1041 PERMIT APPLICATION SUBMITTAL  
FOR  
TOWN OF RAMAH WASTEWATER SYSTEM  
SEWER LIFT STATION  
&  
WASTEWATER TREATMENT PLANT

JULY 2022

EE Job No.: 0043.0001

EXHIBIT L – LAND USE MAP

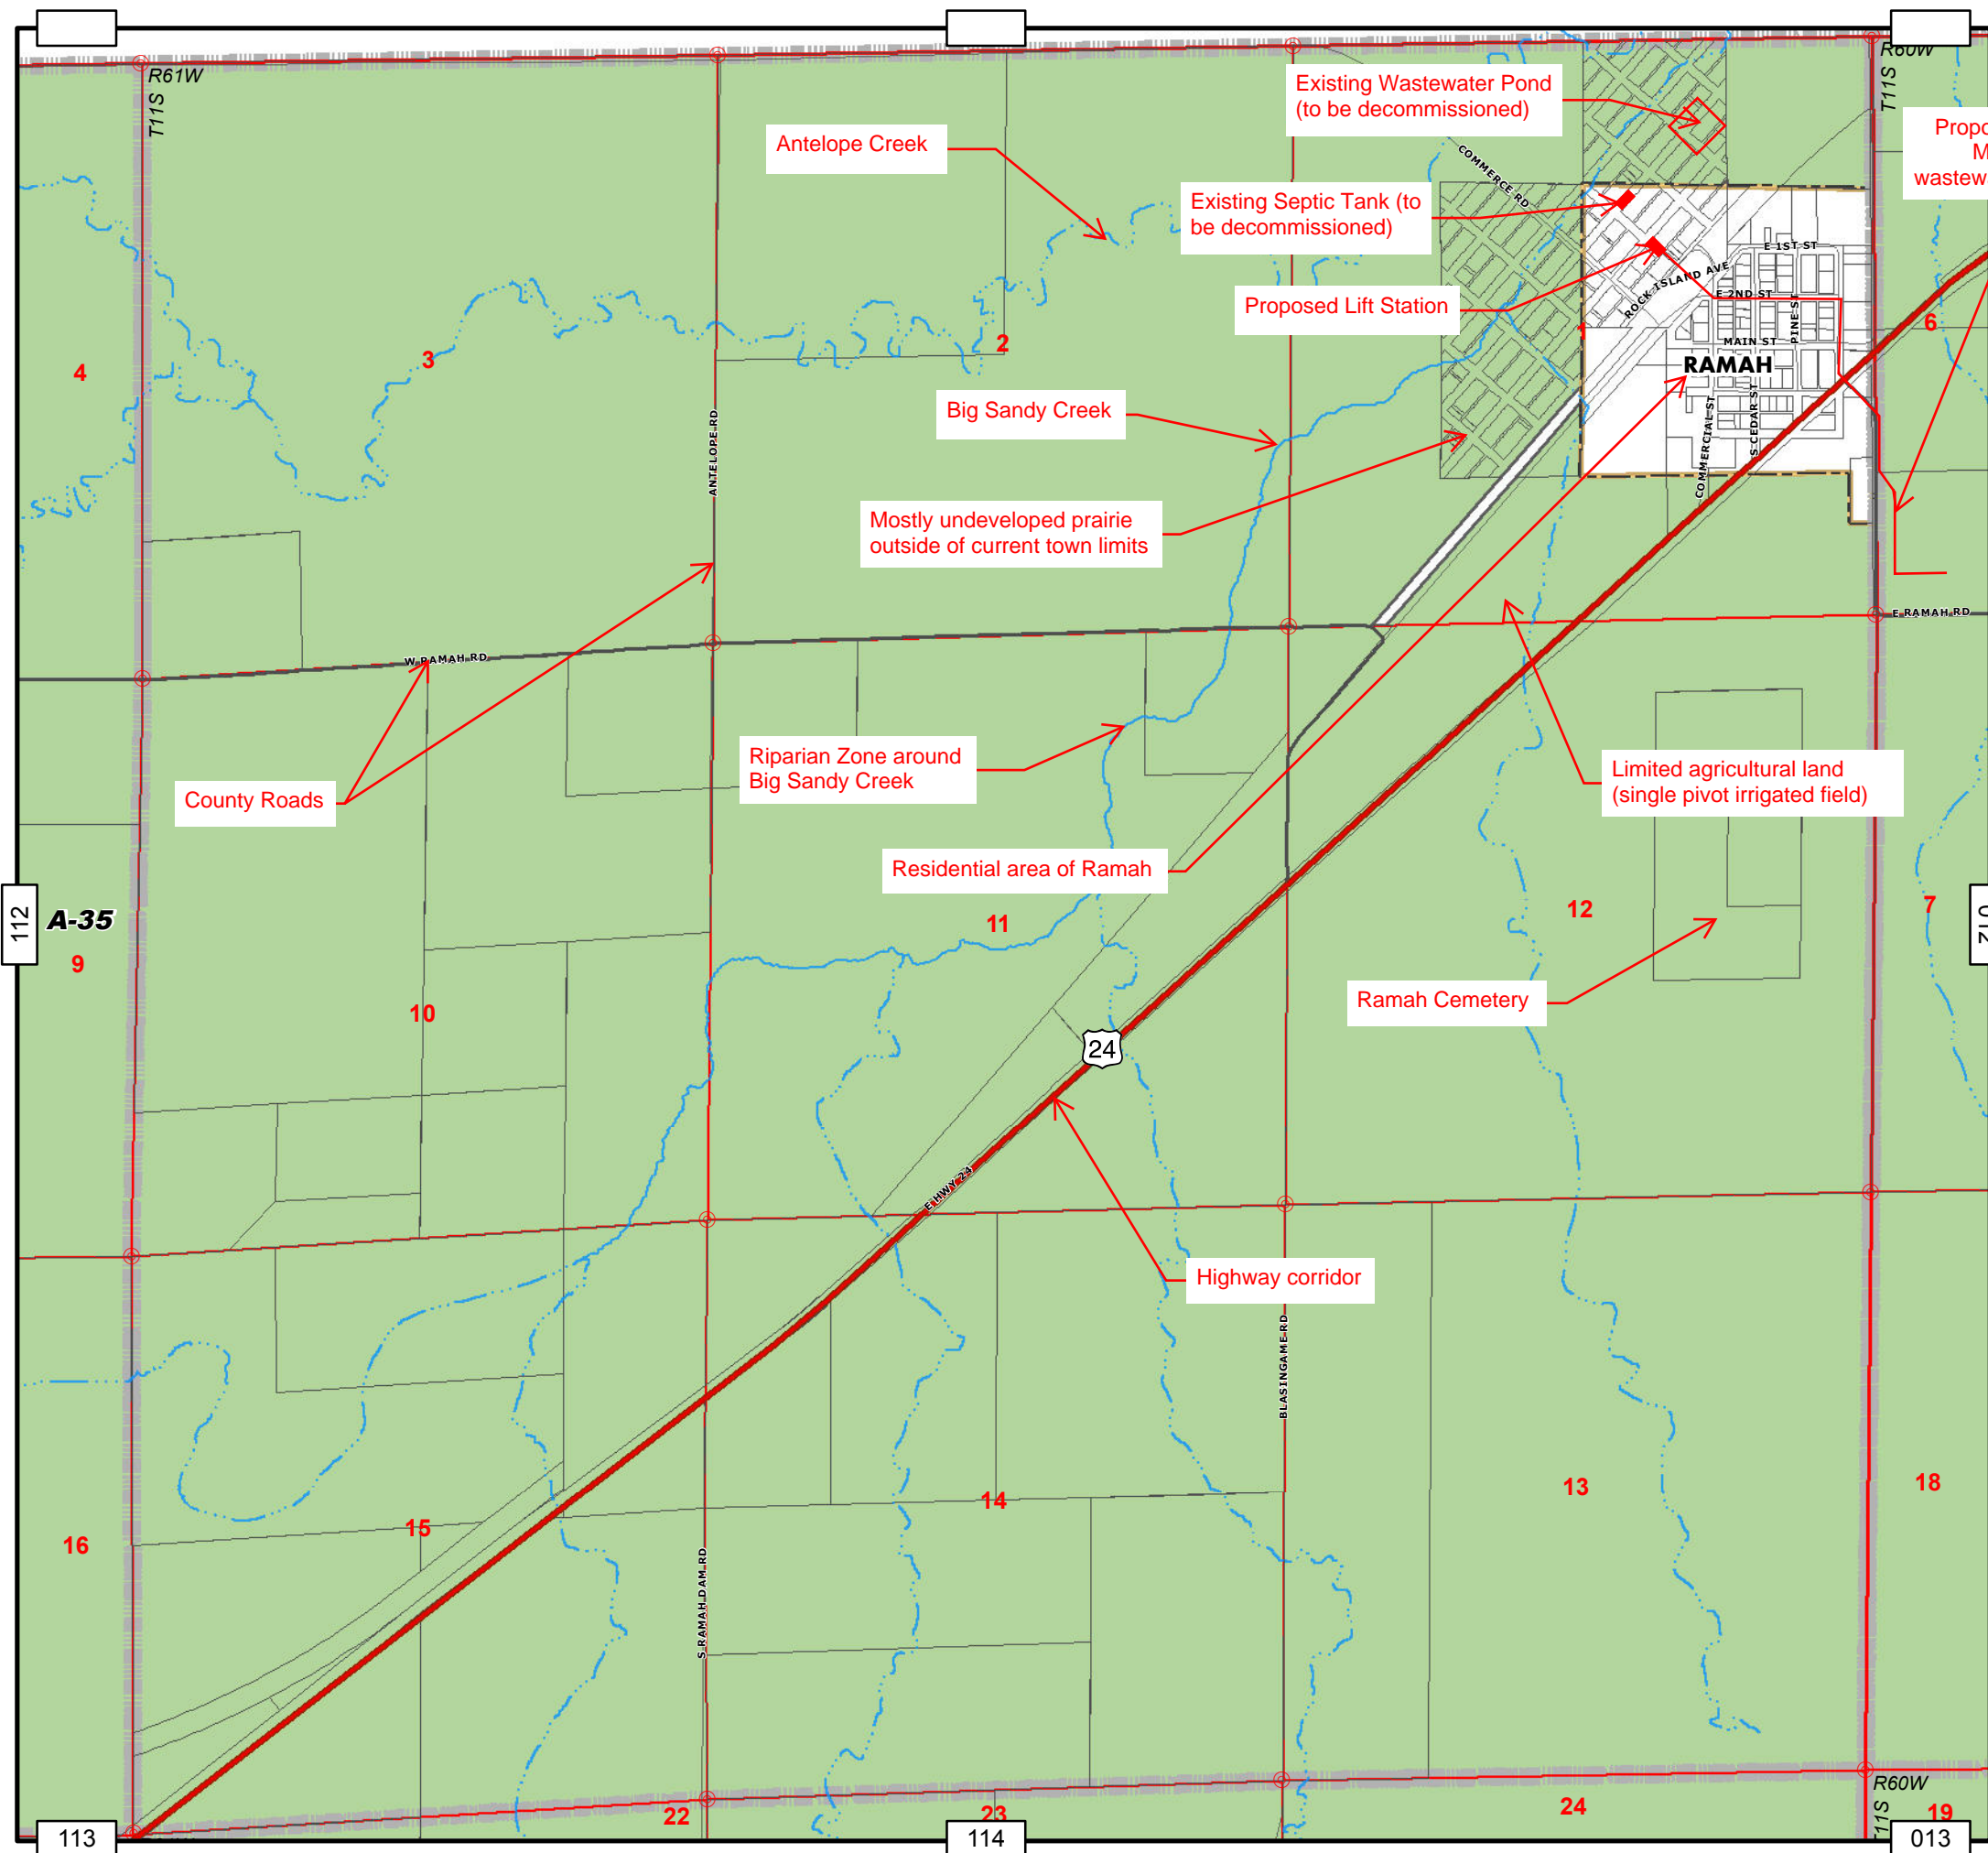
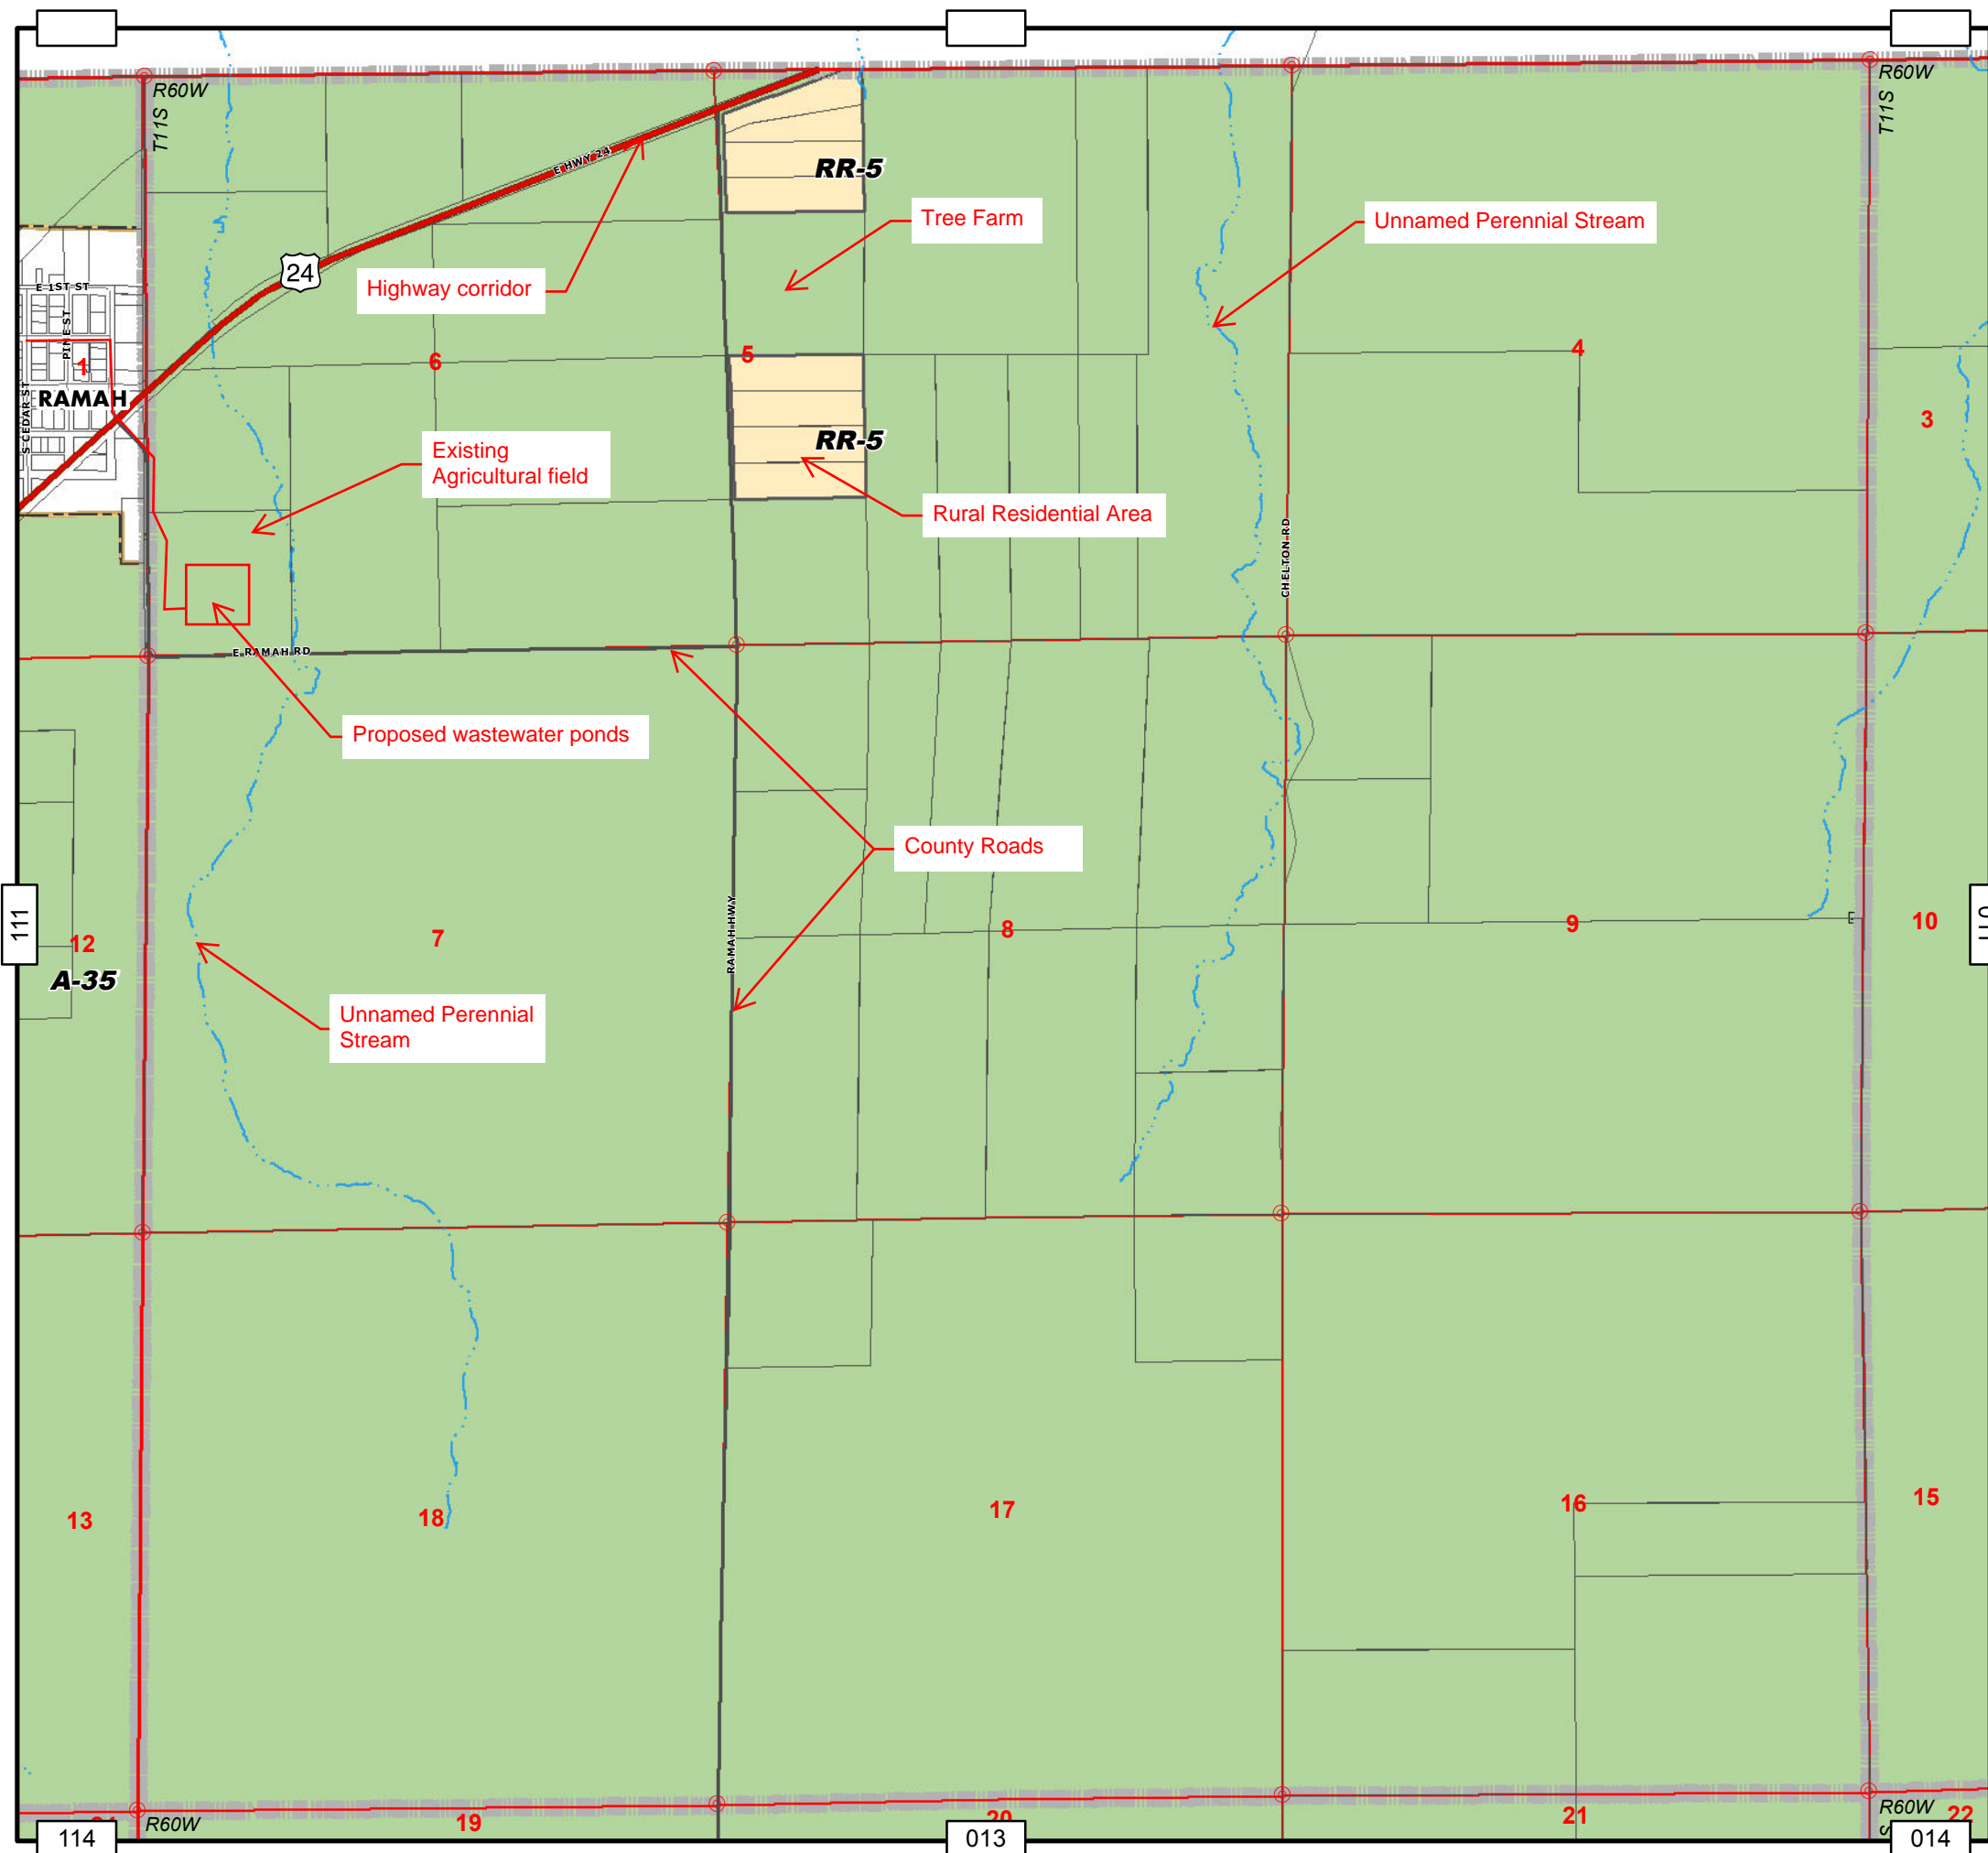
this should be whats physically on the ground- add to the map see redlines.
